From: Ian Garrity <ian@builtprefab.com>
Sent: Friday, October 3, 2025 9:44 AM
To: Ellie Myers
Cc: Jamey Ayling
Subject: Re: 1151 Wapiti Drive OOS plan

From: Ellie Myers <ellie.myers@co.kittitas.wa.us>
Sent: Monday, September 29, 2025 4:02 PM
To: Ian Garrity <ian@builtprefab.com>; Josh Pozzobon <josh@builtprefab.com>; Dan Suggs <dan.suggs@co.kittitas.wa.us>; mcn.ellensburg@gmail.com
Cc: Jamey Ayling <jamey.ayling@co.kittitas.wa.us>
Subject: 1151 Wapiti Drive OOS plan

SITE PLAN

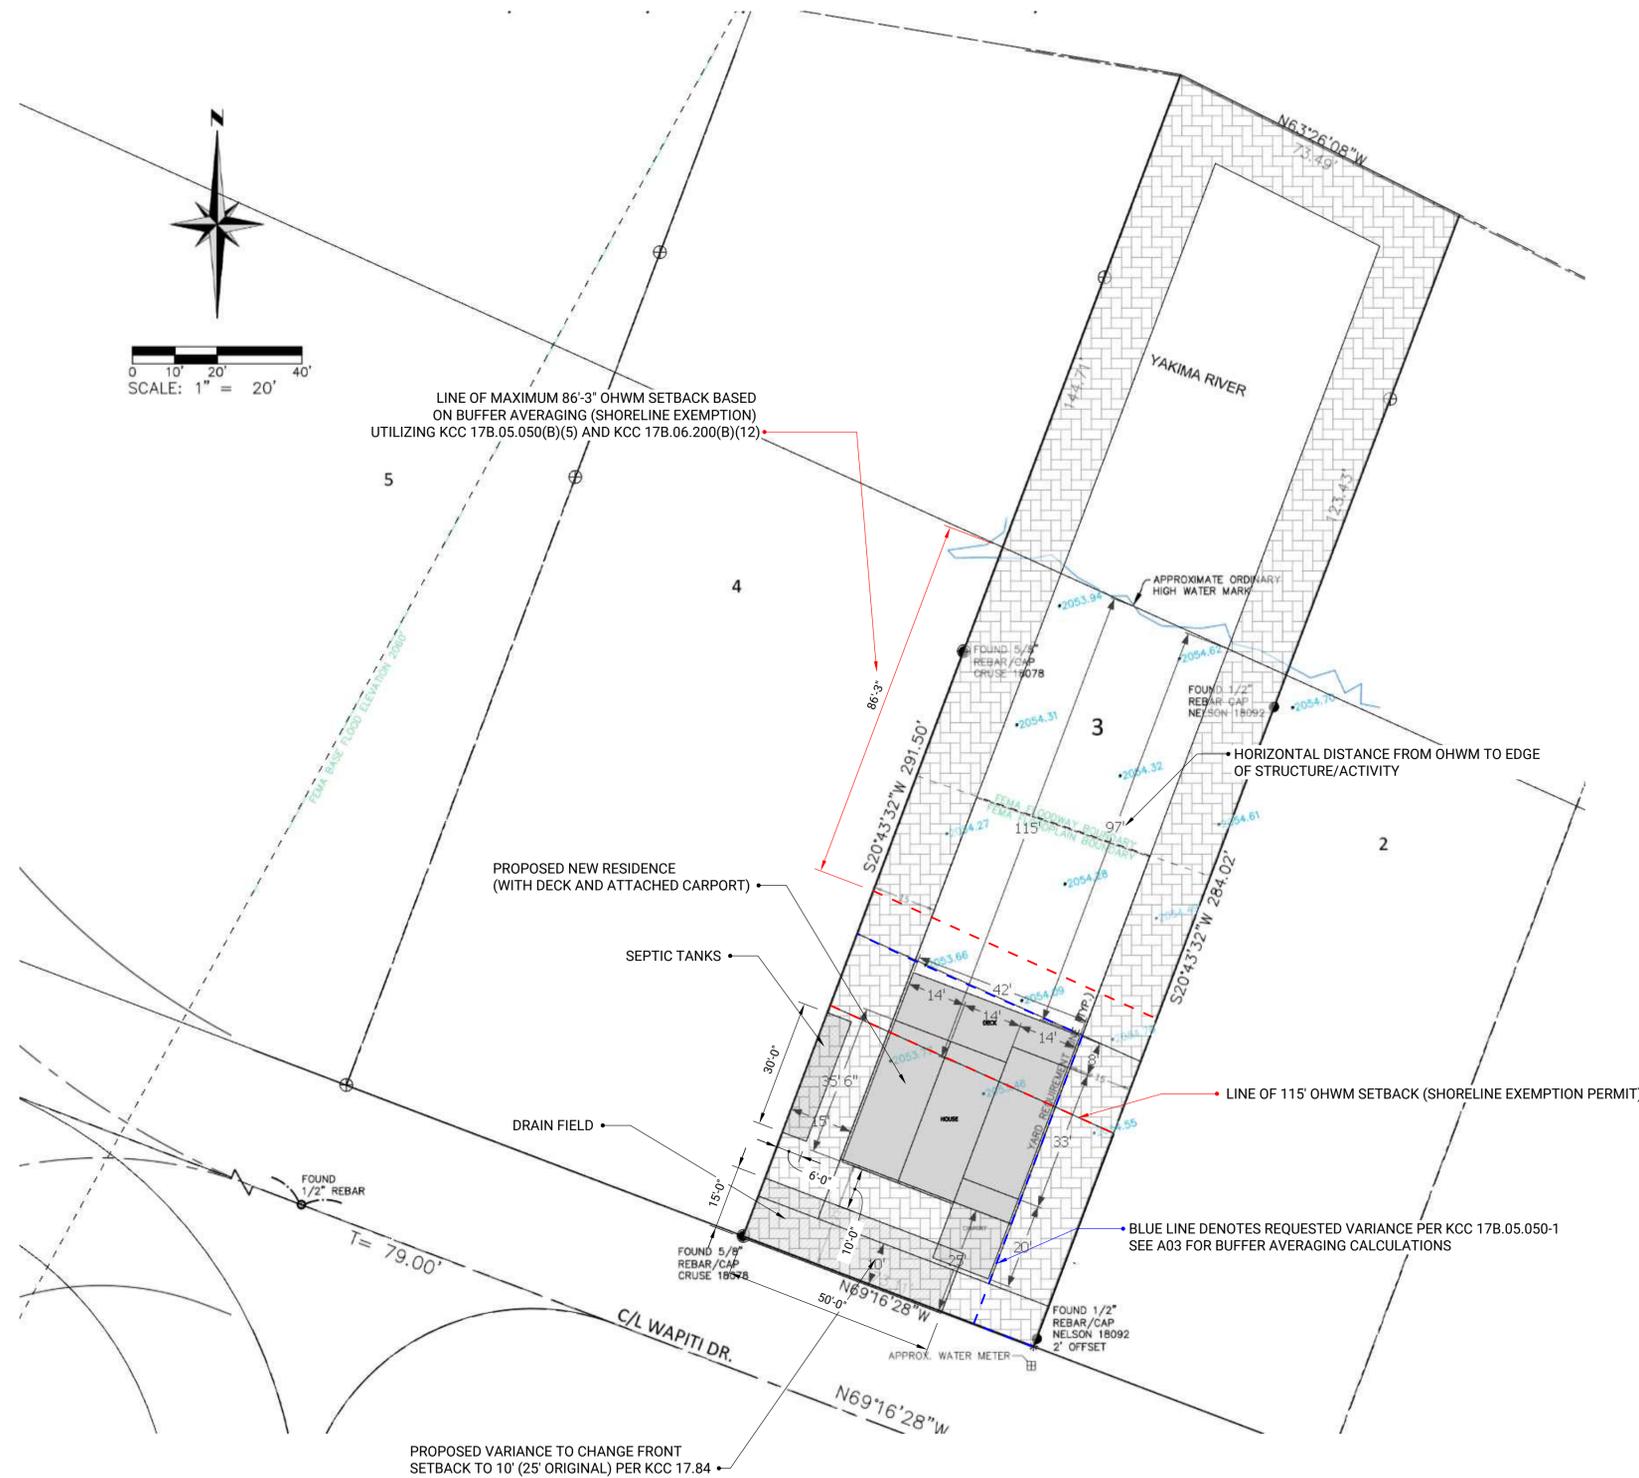
I have attached a copy of the OSS permit and design we have issued for this parcel. The building site plan does not provide enough space for the planned OSS. If you need to revise your OSS plans you should consult with your designer.

Before I send the variance out for public notice, I want to confirm that the proposed location of the septic system and drain field complies with Public Health standards. I've cc'd Dan for his input, as well as Mark Nelson, who designed the original OSS.

We're going to reconvene next week, but that's basically the path forward: ~9x44 primary drain field on the southern property line (streetside) + ~9x44 reserve drain field up the western property line inside of the shoreline buffer

We are okay with the reserve drain field being placed within the shoreline buffer on the condition that it is not excavated until/if the main drain field fails. If the main drain field does fail, the owners will need to apply for a shoreline variance before any excavation. That may help clear up some of the area in front of the house.
